City of Albuquerque Stormwater Construction Site Inspection Report

ESC File No.	K09E048E	Project Name:	Goodwill		
NPDES Id. No.	NMR1006R2	Location:	270 98th St NW		
10/21/2024		Owner	Contractor		
Operator		Goodwill Industries of New Mexico		Architectural Contractors Inc	
Contact name & title		Shauna Kastle CEO		Scooter Haynes	
e-mail		skastle@goodwillnm.org		Scooter@scmpartners.com	
Contact Phone #		505-881-6401 ext 9		898-6622	
COA Inspector		James Hughes		Time	9AM
Construction Phase:		Plumbing & footers			
Type of Inspection:	<input type="checkbox"/>	<input checked="" type="checkbox"/> Regular	<input type="checkbox"/> Storm Event	<input type="checkbox"/> Post Storm Event >0.25"	<input type="checkbox"/> 311/Complaint <input checked="" type="checkbox"/> Follow Up
Weather at time of inspection?				Temperature: ~	50
Estimated date of last storm 0.25" or greater				10/19/2029

| Sheet: EROSION CONTROL PLAN |                 |

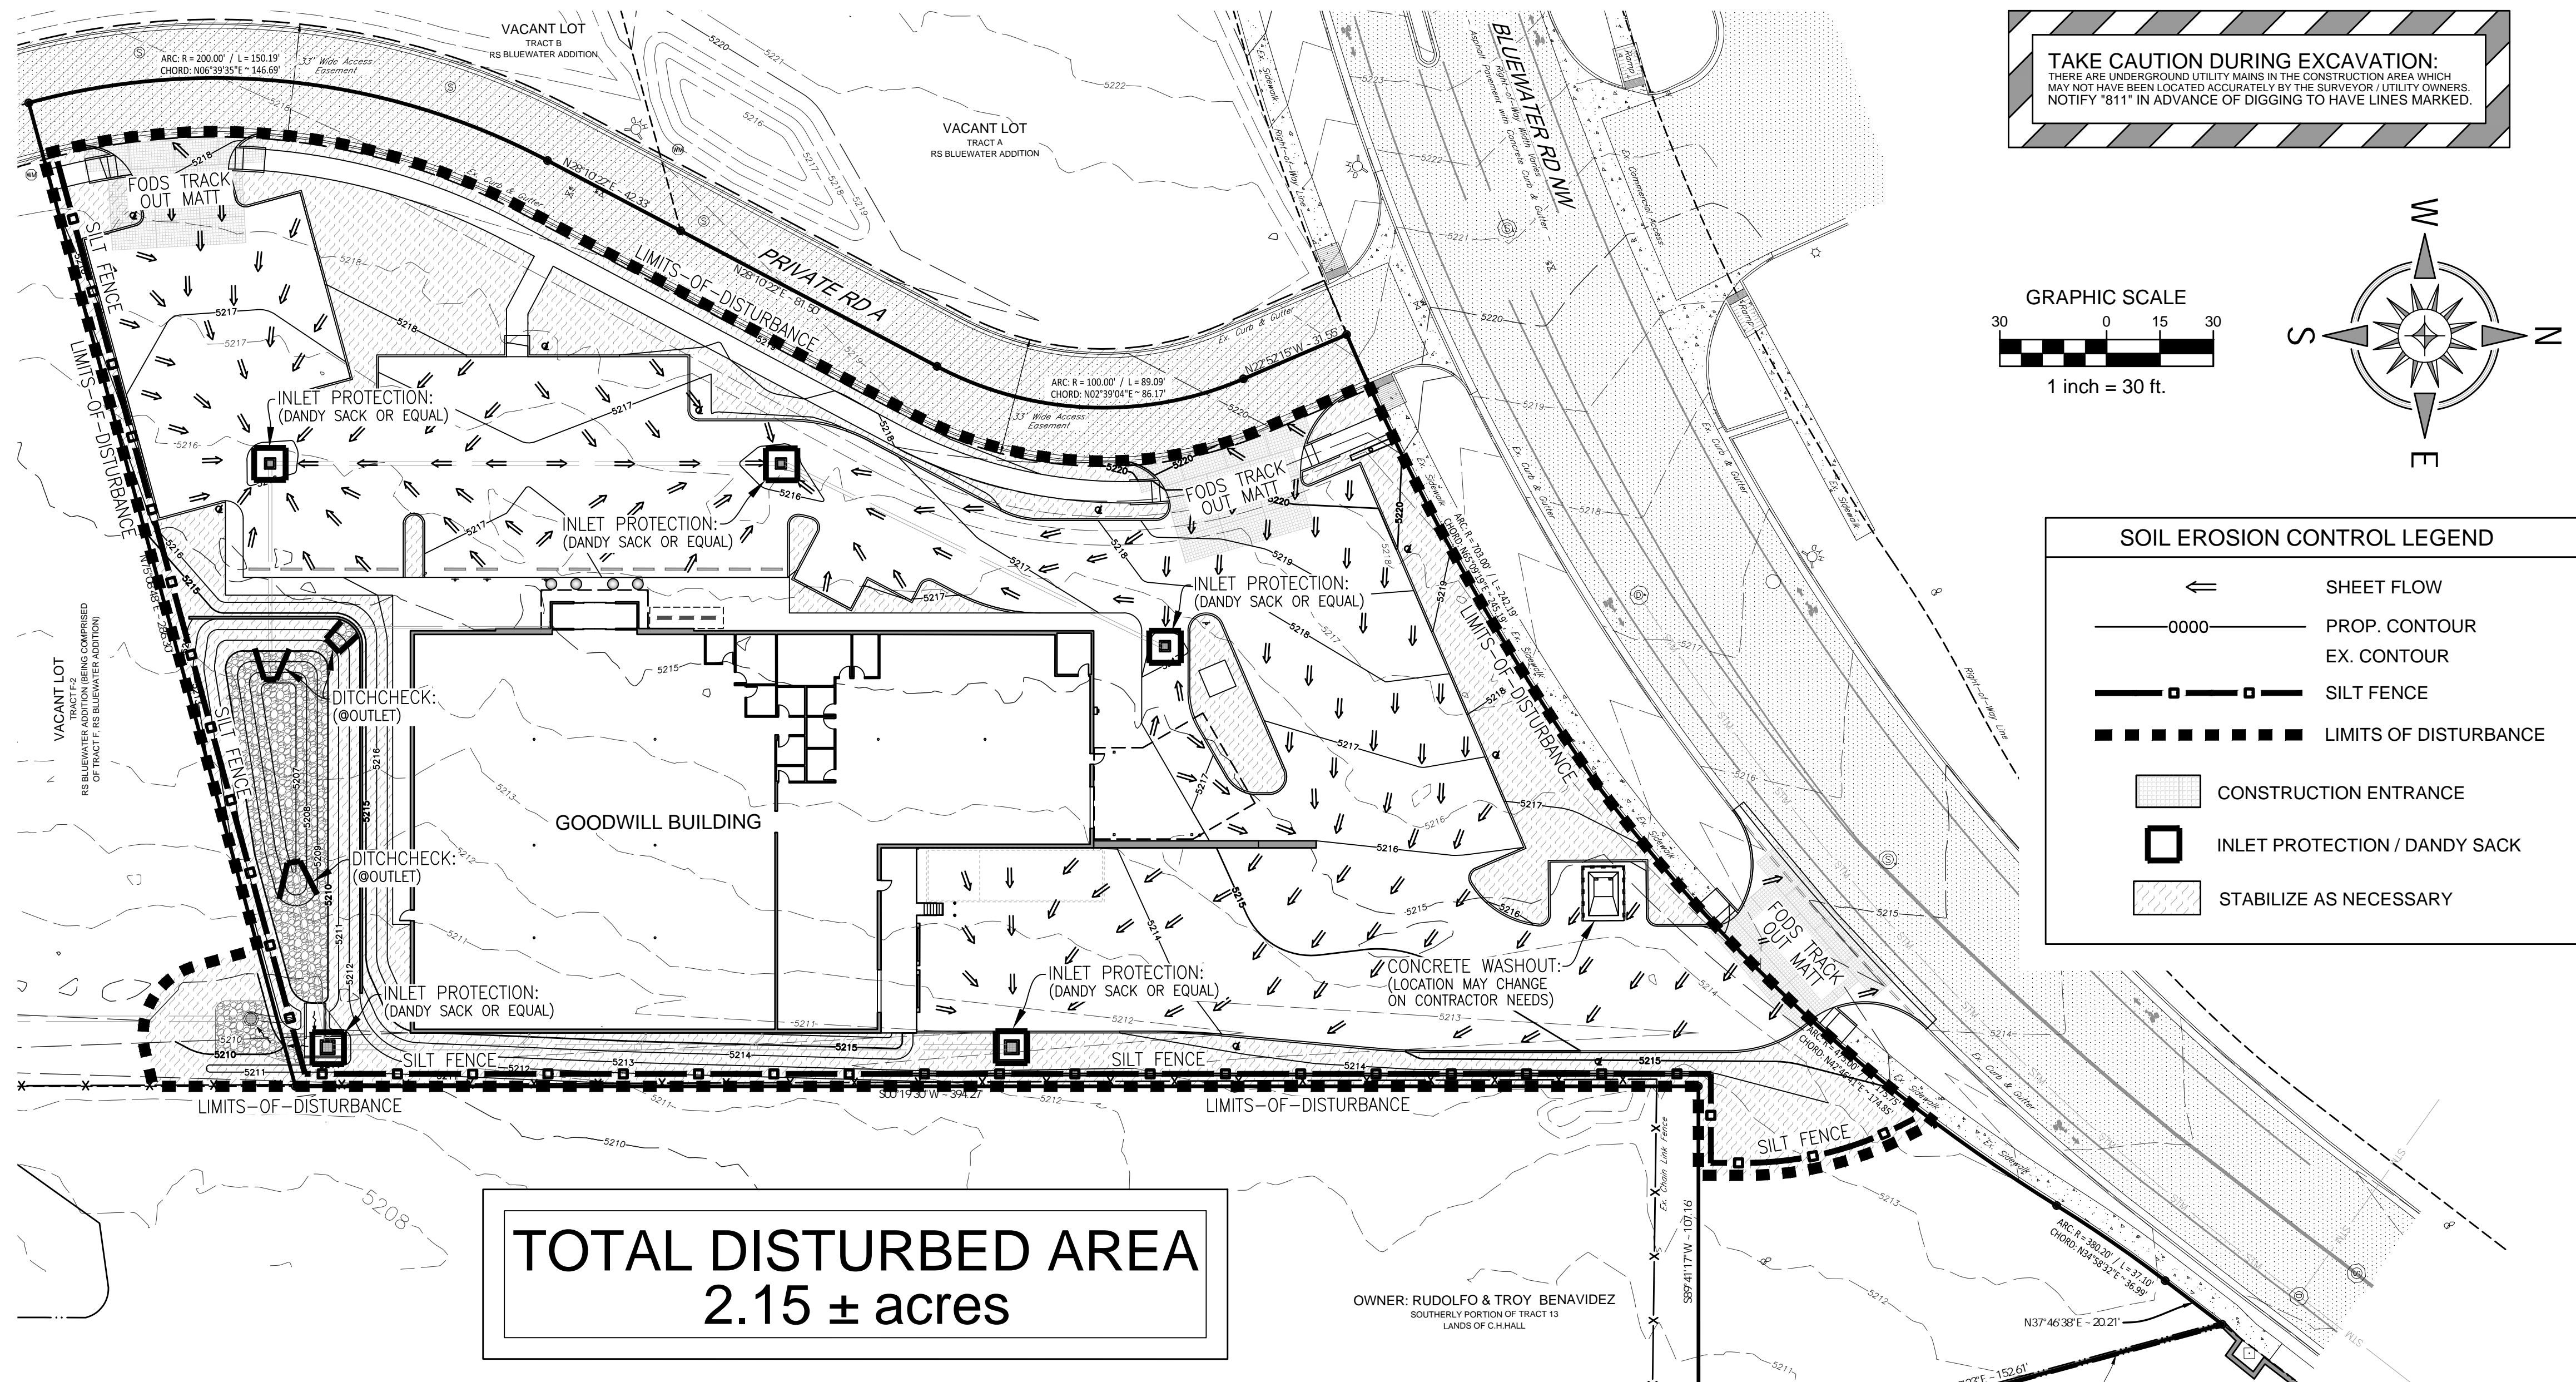
4	BMPs - Perimeter Silt Fence (SF) was in place, but the Construction Exit (CE) was missing. The site drains to the Southeast Corner, where concentrated flow exits the site. The SF in the SE Corner is inadequate for concentrated flow. Additional stormwater controls are not designed in violation of CGP 2.1.4, which requires the Operator to "Design and install all stormwater controls in accordance with good engineering practices, including applicable design specifications." The installation of the stormwater controls wasn't complete before the beginning of Construction Activities in Violation of CGP 2.1.3. Required mitigation: Additional stormwater controls, ponds, berm, and CE must be designed and installed in accordance with CGP 2.1.4 no later than seven (7) calendar days from the time of discovery per CGP 5.2.1.			
5	Stabilization —About half of the perennial vegetation was removed from this site in a 35' wide strip around the edges plus about 0.25-acre pad site in the south 80 of the site as part of the subdivision development that started in late 2022, and this site was still under permit coverage when Goodwill purchased it on 12/29/2023. The edges were Hydromulched in mid-2023 but didn't grow significant perennial vegetation, and the mulch had large bare spots before the end of 2023. The pad had thin spotty gravel cover in Aug 2024. At the time of the inspection on 10/21/24, the previously disturbed area had been scraped, moving vegetation and trash into piles, but the area of native vegetation remained undisturbed in the center third of the lot. Required Mitigation: Stabilize the disturbed areas that remain inactive for 14 days or more per CGP 2.2.14.c.i. Measures must be initiated within 14 days and completed no later than 14 days per CGP 2.2.14.
